EL PASO COUNTY

1/5/2018

Subject: Judge Orr RV Park – Site Development Plan – (PPR-16-040) – review #2

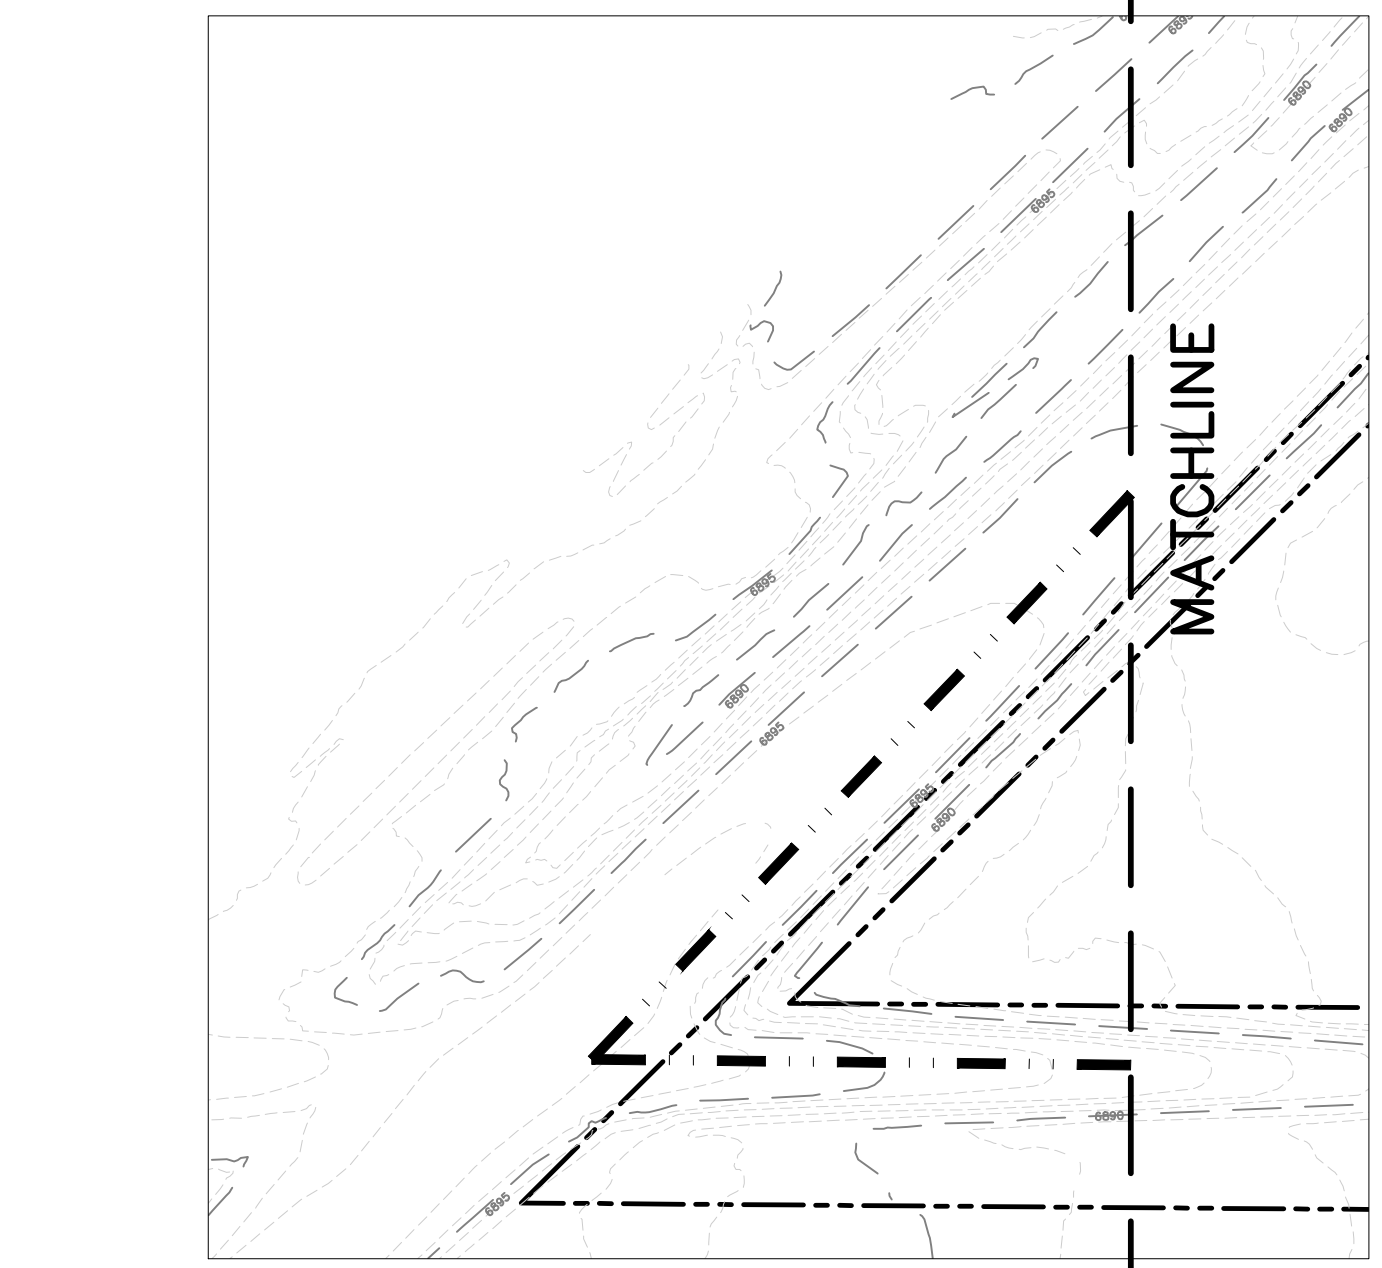
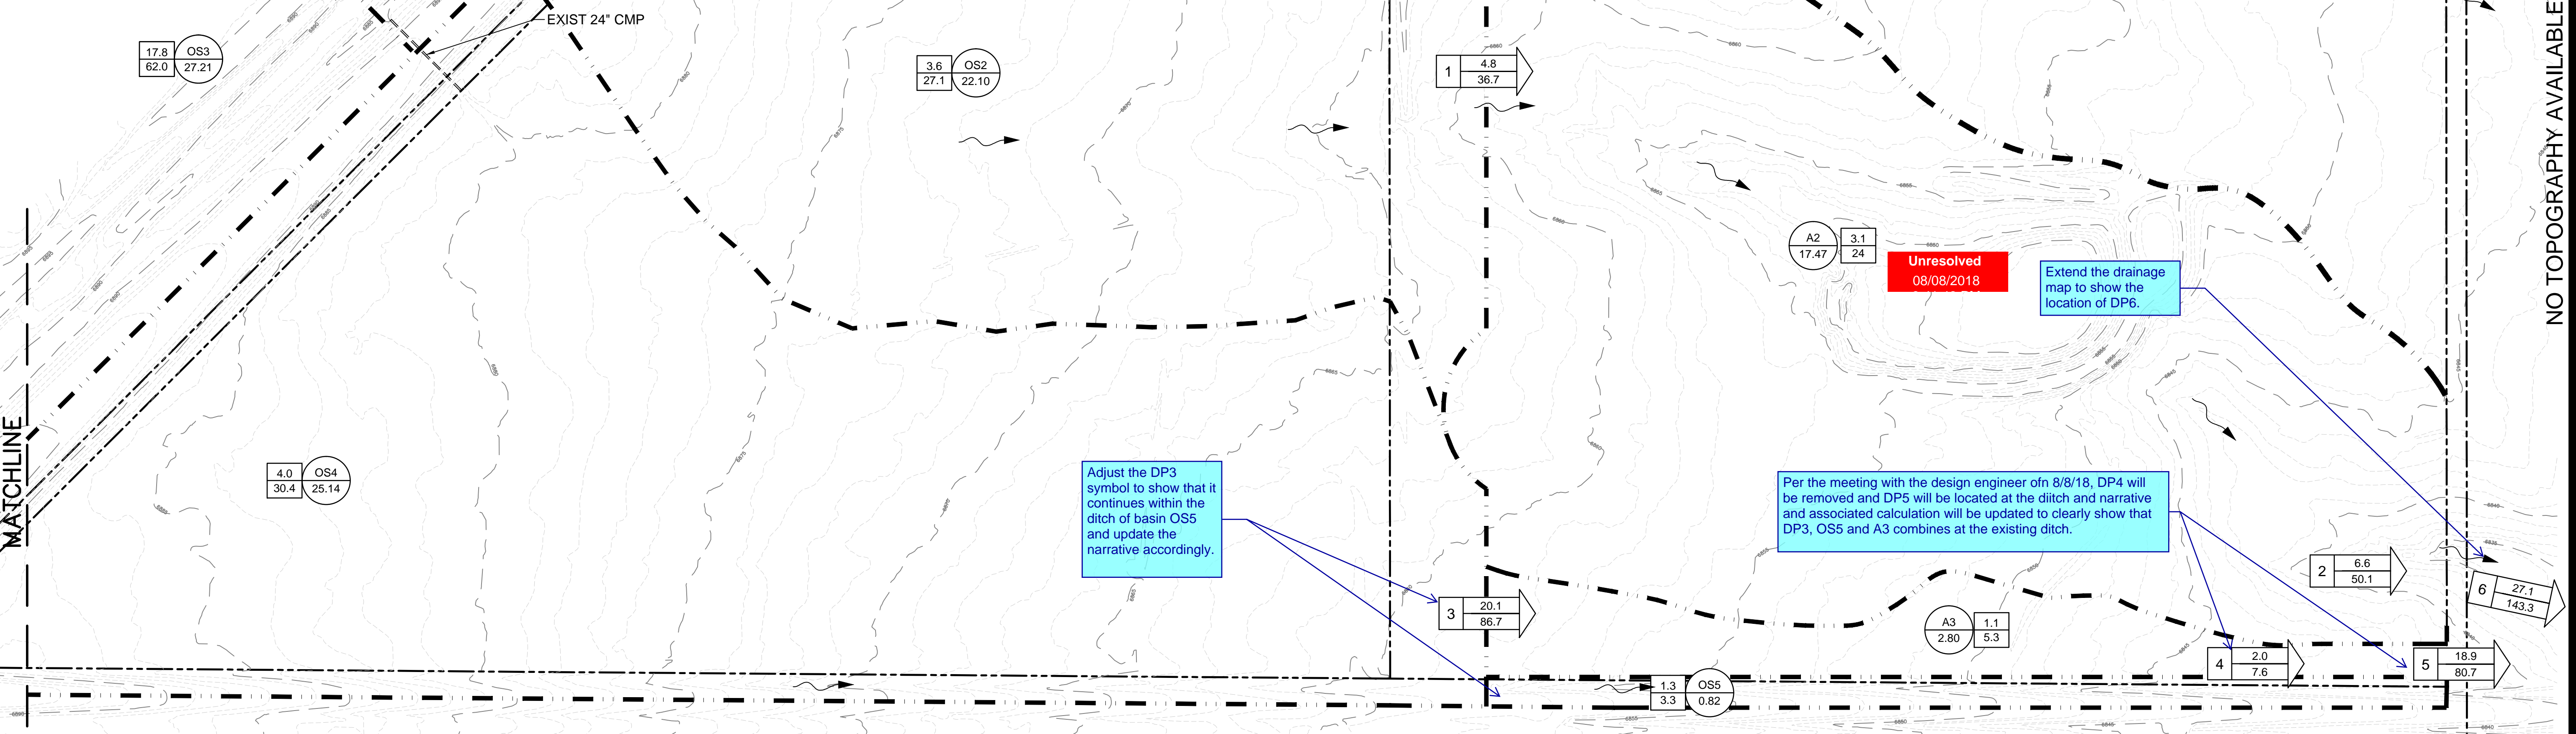
1. Existing condition:
 - a. Resolved.
 - b. **In page 3 Sub-Basin A3. The last sentence identified the ultimate outfall as DP7. The existing drainage map shows this as DP6. Update to match.**

- e. **Add contour labels to the existing contours**
8. Resolved.
9. Resolved
10. Resolved.
11. Appendix B
- a. Resolved.
 - b. Resolved.
 - c. Provide the ditch capacity calculation for the swale along the western property line which conveys runoff from OS1 and the swale along the eastern property line. **For the ditch capacity calculation, include the manning's roughness coefficient used.**

JUDGE ORR ROAD RV PARK & STORAGE
 COLORADO SPRINGS, COLORADO
 DRAINAGE - DEV OVERALL CONDITIONS

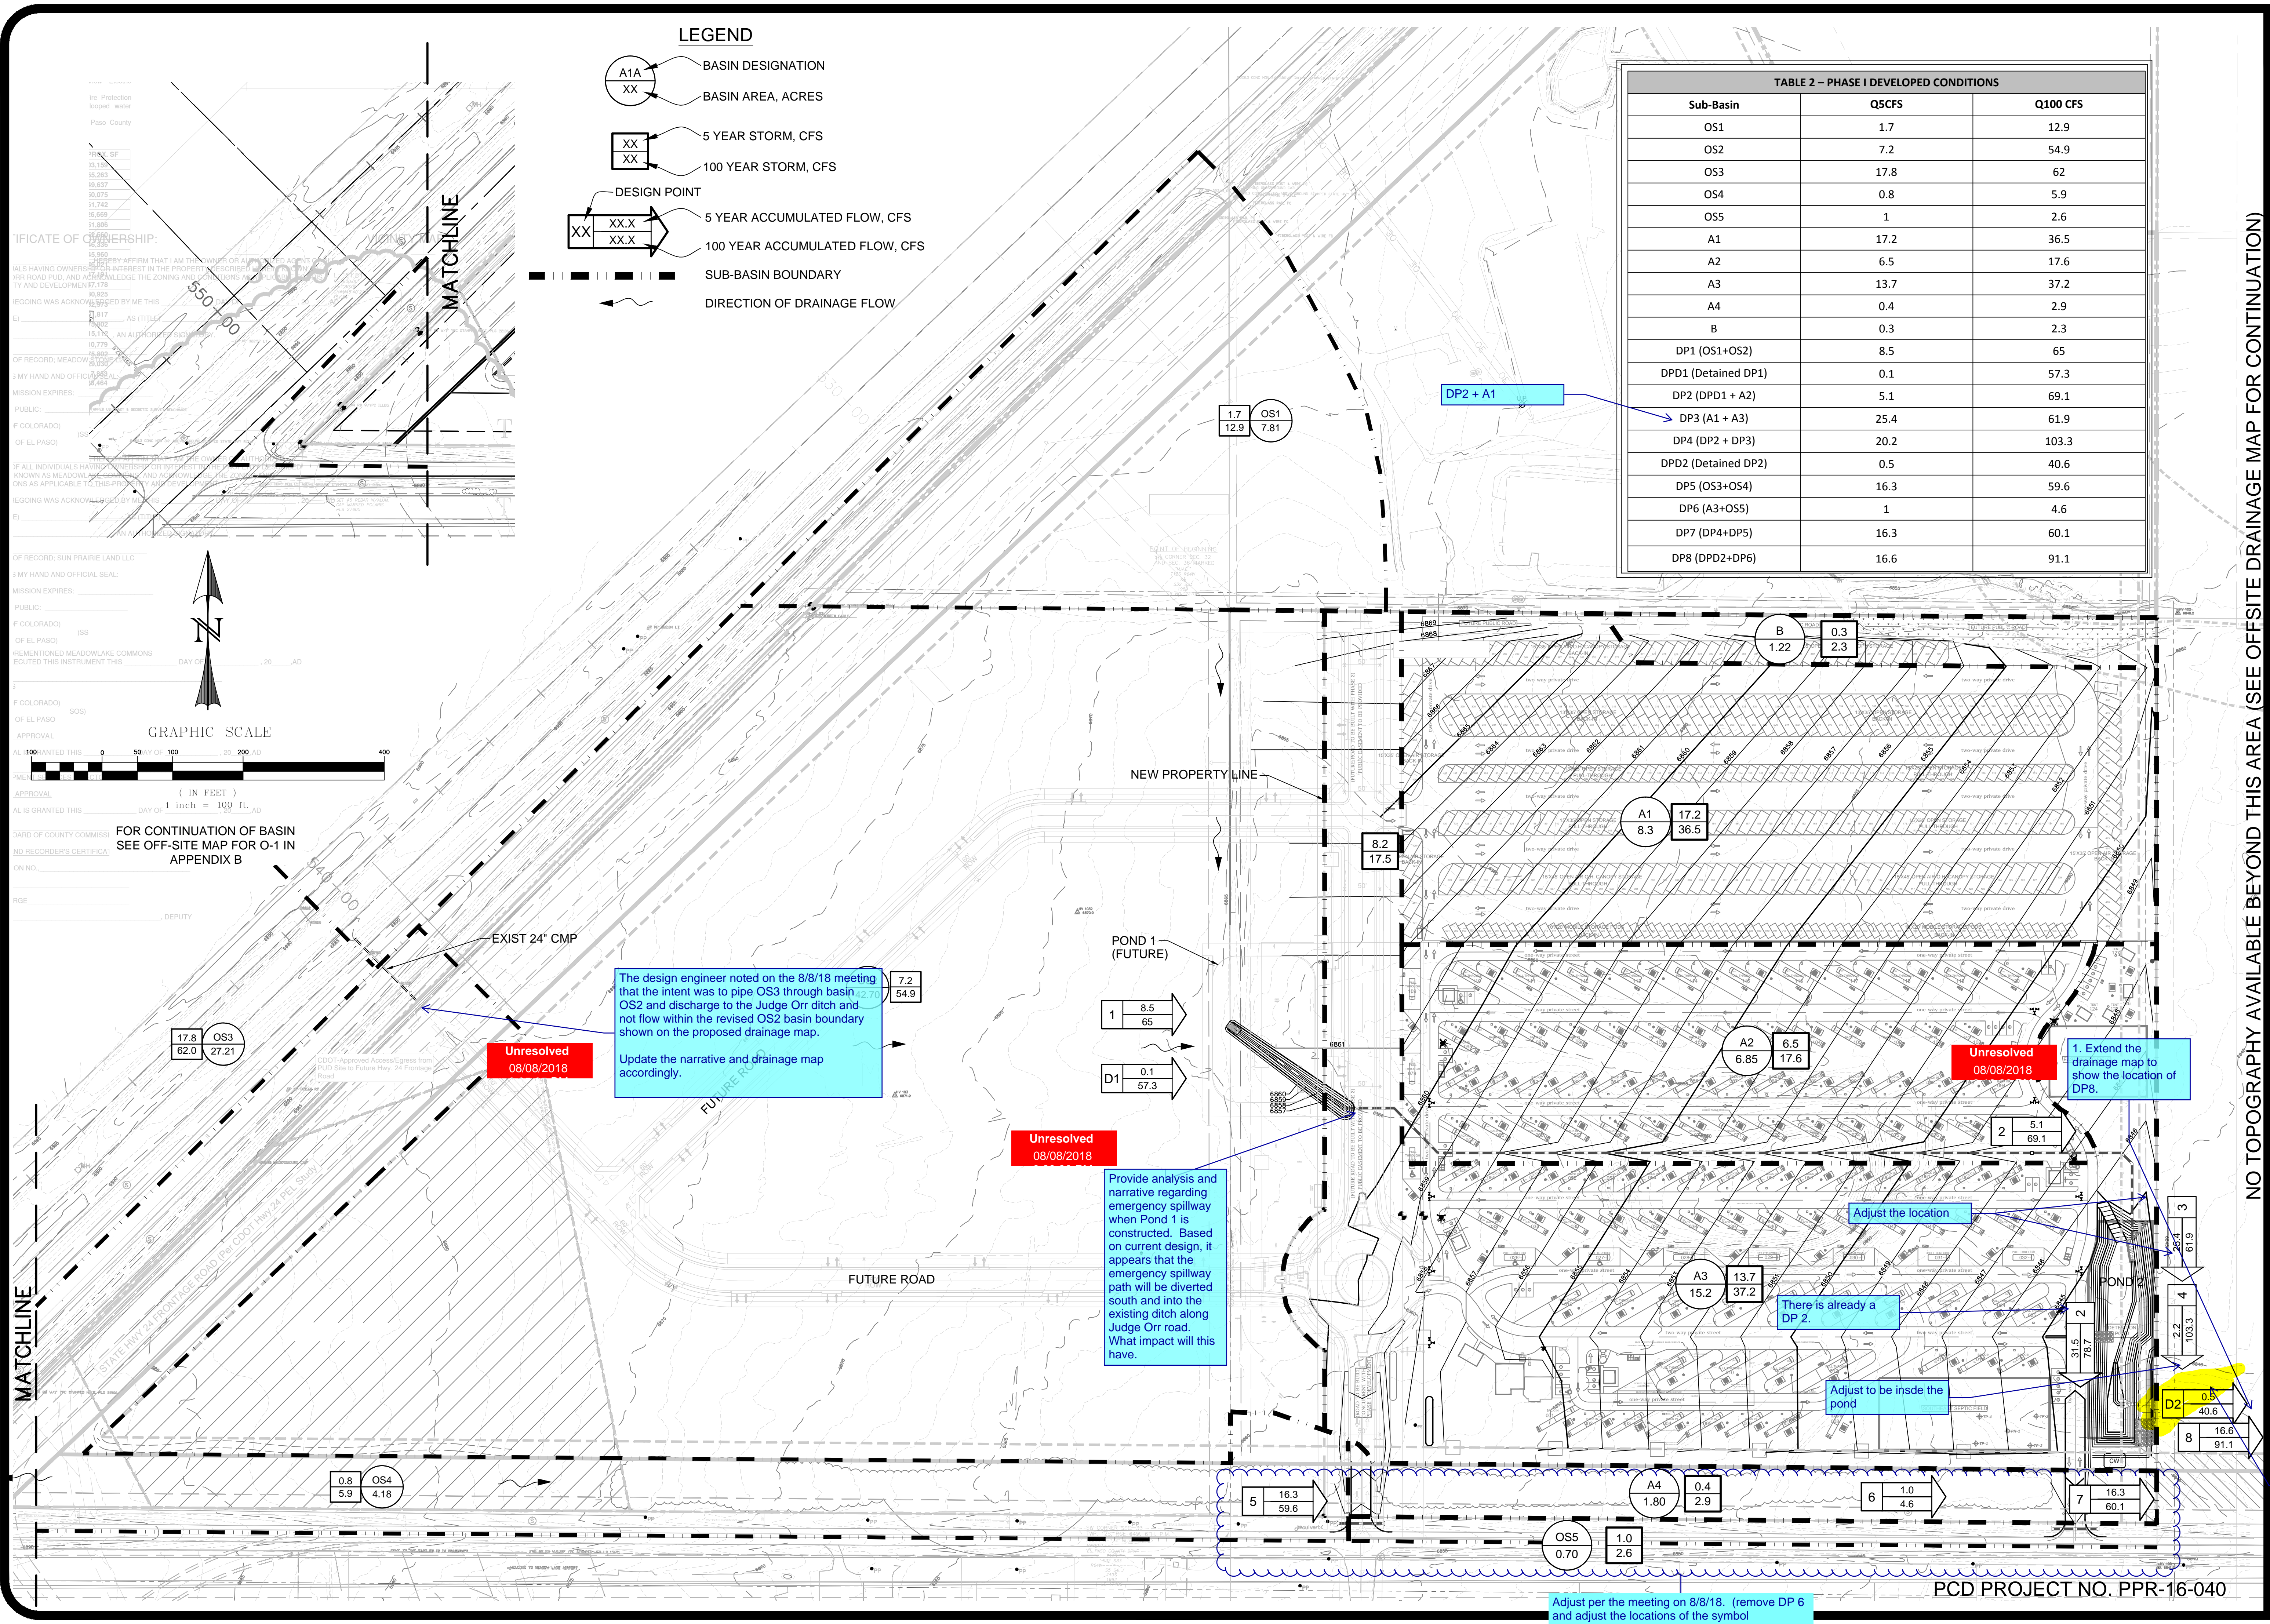
2. Developed condition:
 - a. N/A.
 - b. Provide culverts at the two driveway locations. Include supporting culvert, show on the drainage map and provide construction details in the grading and erosion control plan. **Unresolved. Provide culvert calculation which includes the Hw/D.**

- c. N/A.
 - d. Include the narrative for phase 1 sub-basin A. Based on the revised sub-basin identification. Update the text from Sub-basin A to Sub-basin A1 (pg 4). **Unresolved. Elaborate. The proposed drainage map shows gravel area and does not show the full buildout configuration. Is the loose gravel surfacing for phase 1 only or for buildout condition? The pond should be sized for buildout condition, if it is not then identify that a drainage letter is required with development of sub-basin A1 and retrofit of the existing pond will be required. Also, see general comment number 4 above.**

- e. N/A.
 - f. N/A.
 - g. N/A.
 - h. N/A.
 - i. Add a narrative in the developed condition discussing how this project provides drainage accommodation for future development within OS-1, OS-2, and OS-3. How will they tie in to your system or drain to your site? State and identify in the developed drainage map the allowable flow that will flow into DP 1. **Unresolved. Based on the added narrative and proposed stormdrain system, the two ponds function as ponds in a series. The pond associated with the RV Park & Storage must be evaluated as such.**

7. Drainage Maps:
- a. Resolved.
 - b. Resolved.
 - c. Resolved.
 - d. ~~Include a runoff summary table and a pond summary table.~~ **Unresolved. Provide the pond summary (required WQCV, EURV, 100yr Volume)**
